To: Charlotte Planning, Design & Development

From: Doug Lozner

Date of Review: September 27, 2021

Rezoning Petition #: 21-125

Rezoning Site Plan

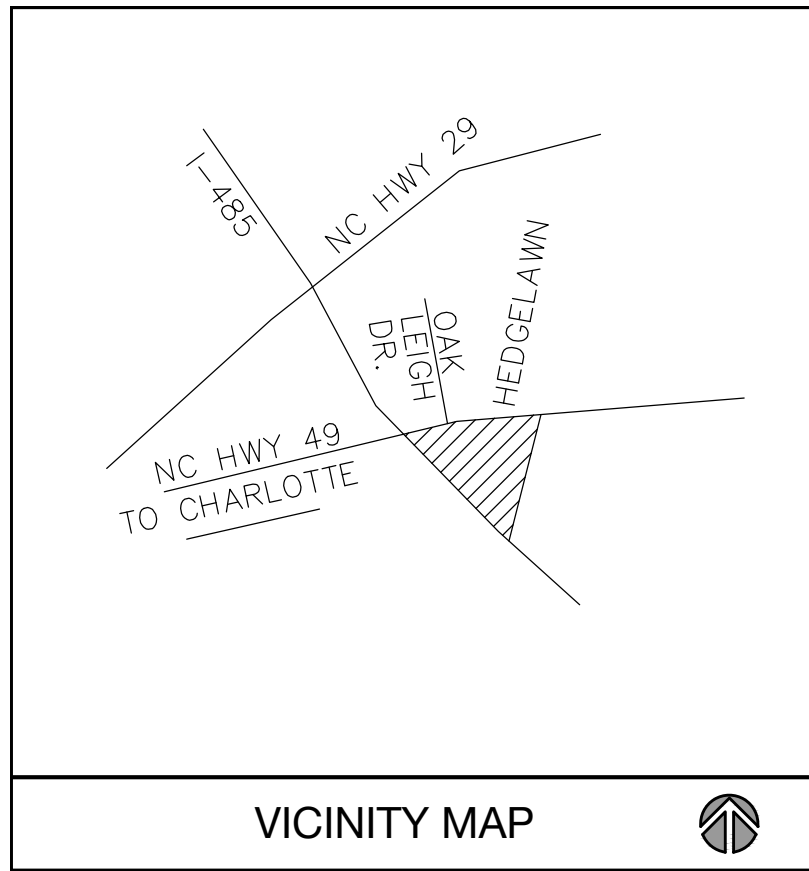
Concerning Storm Water: Please include the following notes under "Environmental Features:

- *The petitioner shall comply with the Charlotte City Council approved and adopted Post Construction Stormwater Ordinance.*
- *Development within any SWIM/PCSO Buffer shall be coordinated with and subject to approval by Charlotte-Mecklenburg Storm Water Services and mitigated if required by City ordinance. Petitioner acknowledges intermittent/perennial stream delineation reports are subject to review and approval upon submission of development plans for permitting and are not approved with rezoning decisions.*
